From: Simon Davis
Sent: 10 November 2020 17:14
To: Planning Scanning
Subject: FW: Y/70/20/OUT

From: Simon Davis
Sent: 10 November 2020 17:13
To: 'Patrick Barry' [REDACTED]
Subject: RE: Y/70/20/OUT

Dear Sarah & Patrick,

Location Plan: 1:2500

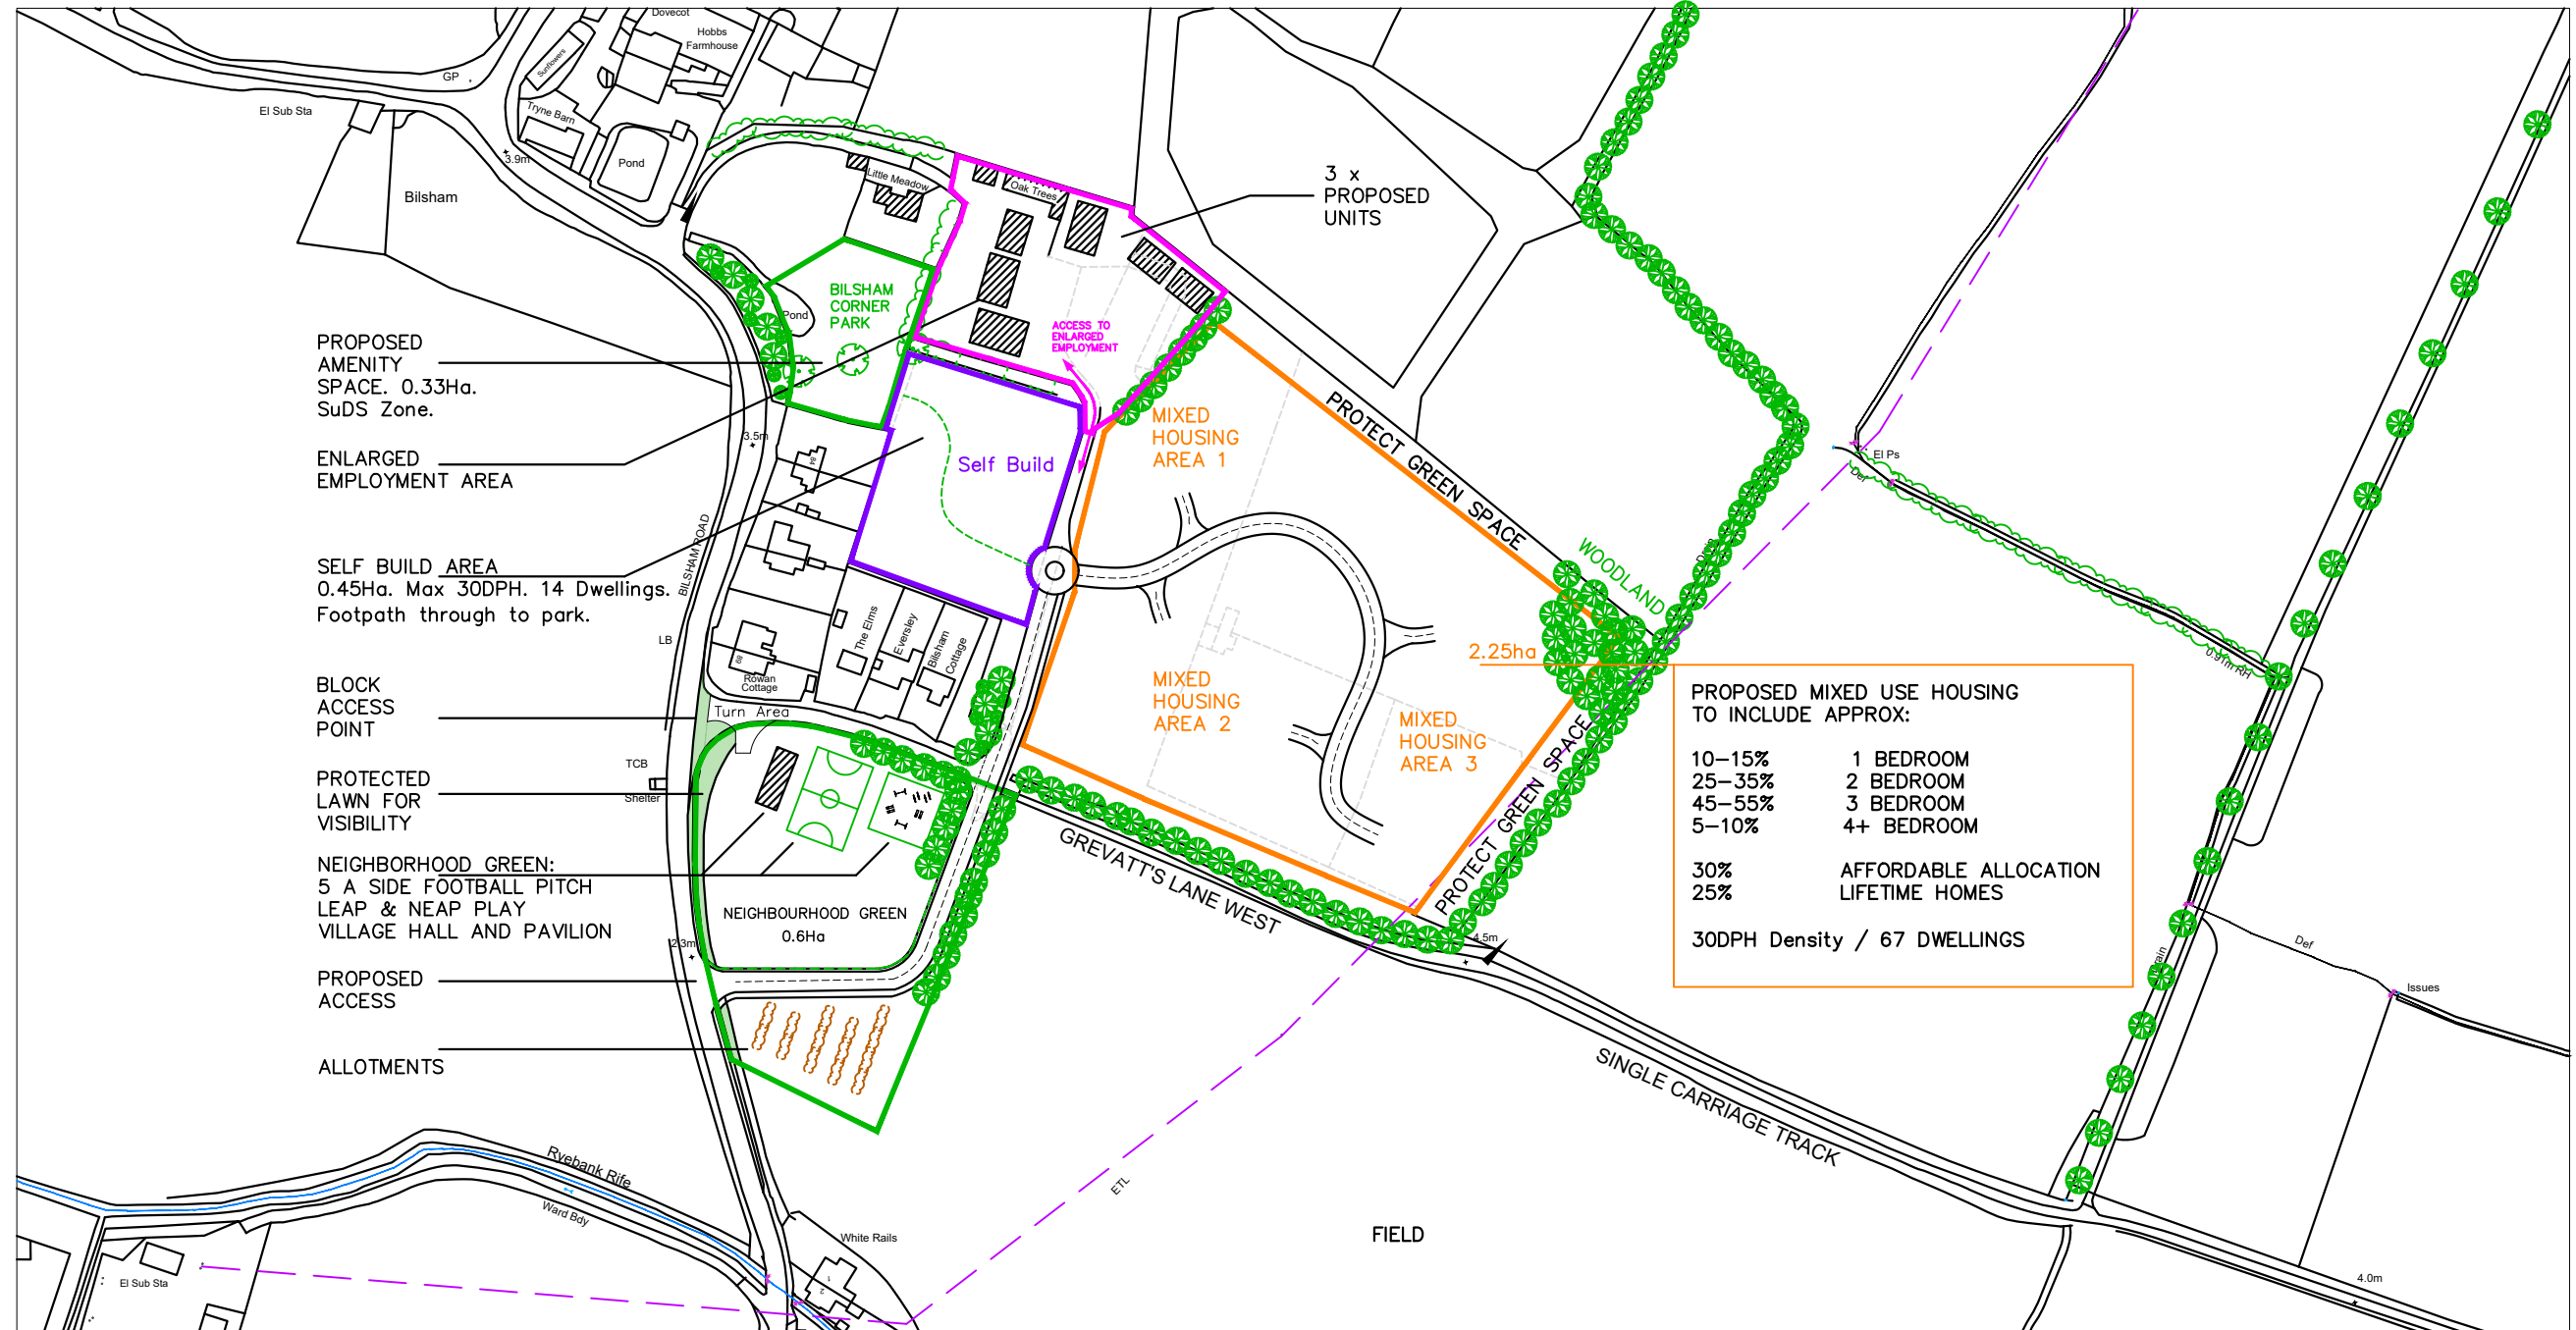
Notwithstanding, I note that the revised masterplan drawing now proposes housing close to the existing homes, two of which are non-designated heritage assets (84 & 85 Bilsham Road) and also has more housing close to the expanded industrial site. These changes would therefore result in potential residential amenity issues, greater harm to the non-designated heritage assets and would also leave a greater number of dwellings at risk of pollution (noise/air) from the industrial units. These matters would require further consideration.
